H2Teesside Project

Document Reference: 9.5: Statement of Common Ground between H2 Teesside Limited and the Marine Management Organisation

Date: September 2024

**Statement of Common Ground between H2 Teesside Limited and the
Marine Management Organisation**

APPENDIX 1: FIGURES 1-4

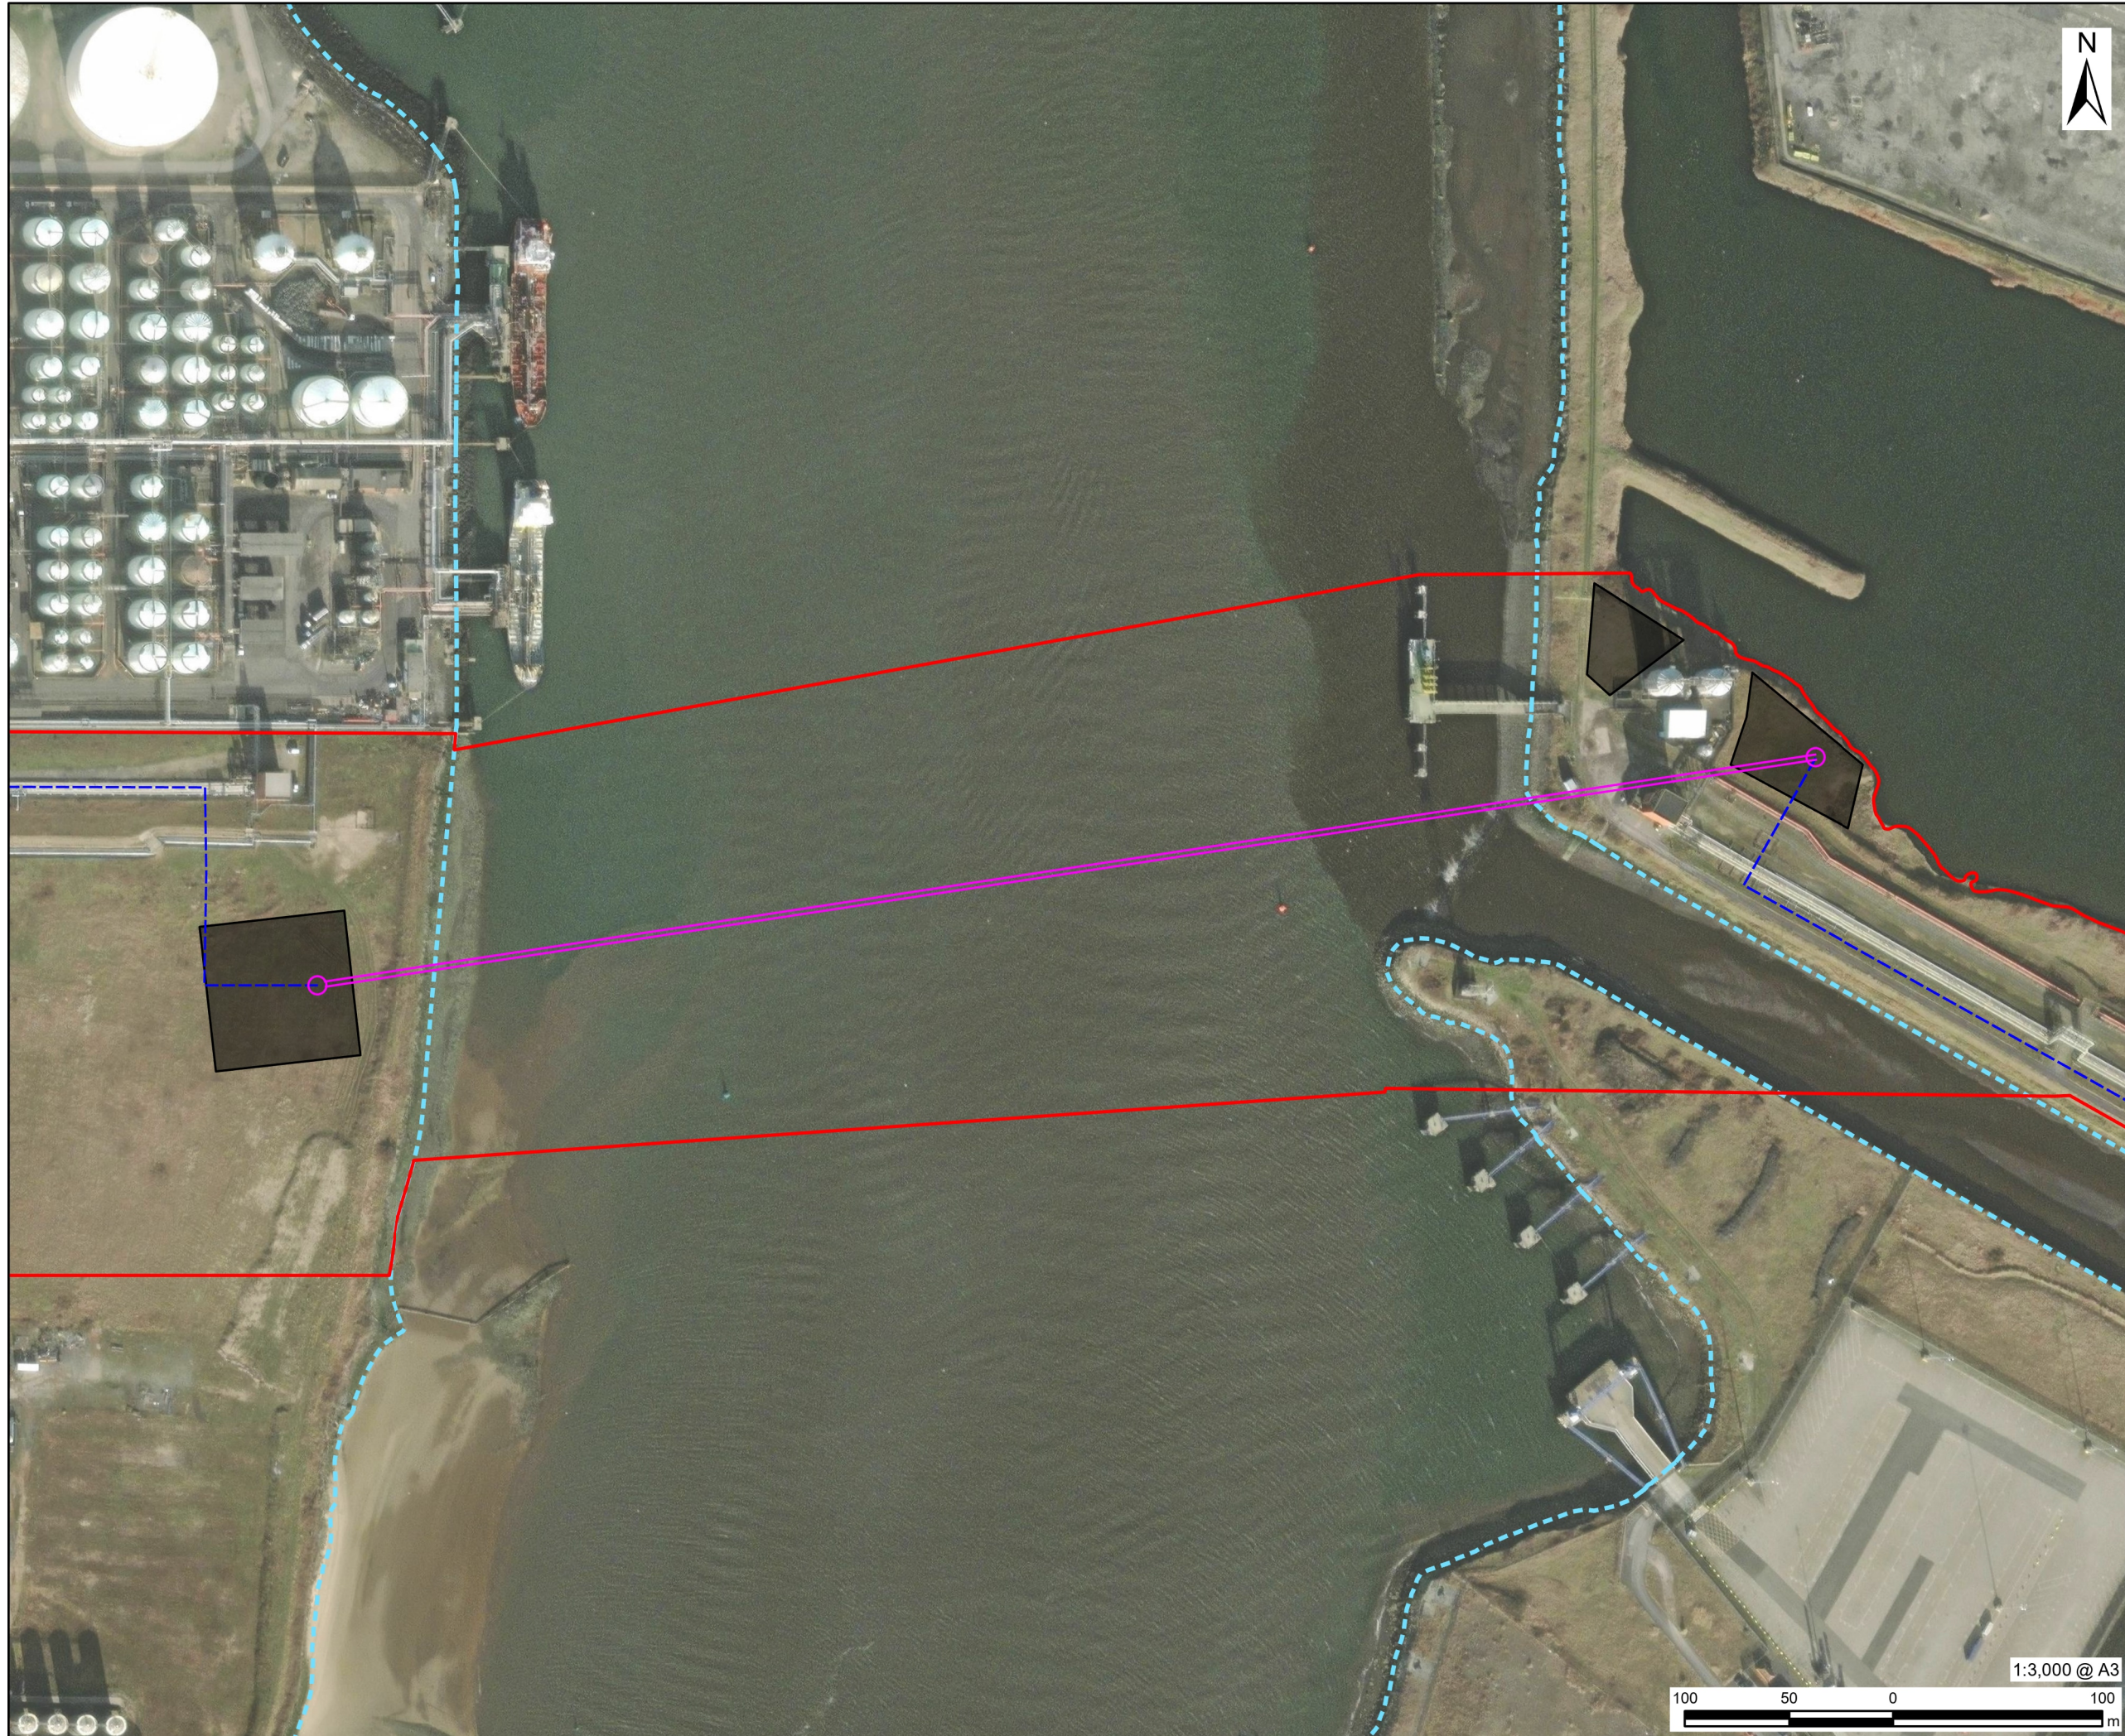
2.	<p>MMO queries whether the risk of Bentonite Breakout is assessed within the ES.</p>	<p>The Applicant considers that it has proposed a sufficient range of mitigation measures to reduce risk of hydraulic fracture (and through this bentonite breakout), set out in Tables 7-2 and 7-5 of the Framework Construction Environmental Management Plan [APP-043], including the need for a Hydraulic Fracture Risk Assessment. Final versions of this plan, developed in accordance with this Framework, are required to be produced pre-construction, as secured by Requirement 15 of the draft DCO [APP-027], and construction of the Proposed Development is required by the DCO to be carried out with the full plans. As such, an Outline Marine and Intertidal Pollution Contingency Plan or Outline Bentonite Management Plan is not required.</p> <p>Monitoring of water bodies during construction works will also be undertaken, pursuant to the requirements of the draft Outline Water Management Plan [APP-045], which is also required</p>	<p>MMO queries whether the risk of Bentonite Breakout has been assessed within the ES and would welcome an Outline Marine and Intertidal Pollution Contingency Plan and an Outline Bentonite Management Plan for review (MMO RR3).</p>

SOCG ID	MATTER	APPLICANT POSITION	MMO POSITION
		<p>to be developed into a full plan, and construction carried out in accordance with it, by DCO Requirement 15.</p> <p>These measures have been accounted for in ES Chapter 9: Surface Water, Flood Risk and Water Resources [APP-061] which discusses bentonite management and the mitigation measures for minimising risk of hydraulic fracture. The assessment concluded that with these mitigation measures in place, no significant adverse impact on water quality of the Tees water body or Greatham Creek resulting from installation of the trenchless crossings is predicted and that with the controls identified above the risk of bentonite breakout is minimal.</p>

Figure 1: Distances from River Tees HDD pits to MHWS. Information and images provided by H2 Teesside Limited.

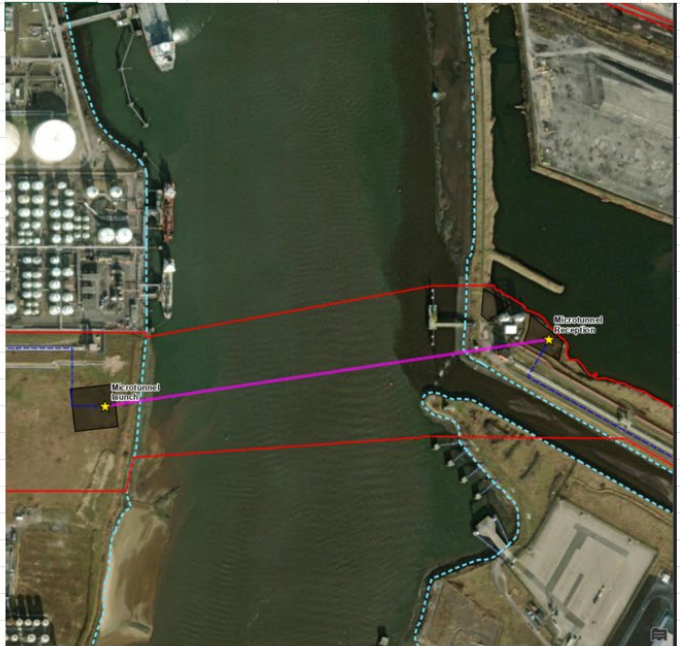
MATTER AGREED	AGREED POSITION
Details of trenchless crossing trial pits	It is agreed that the proposed locations of entry and exit pits for the two trenchless crossings are above MHWS.
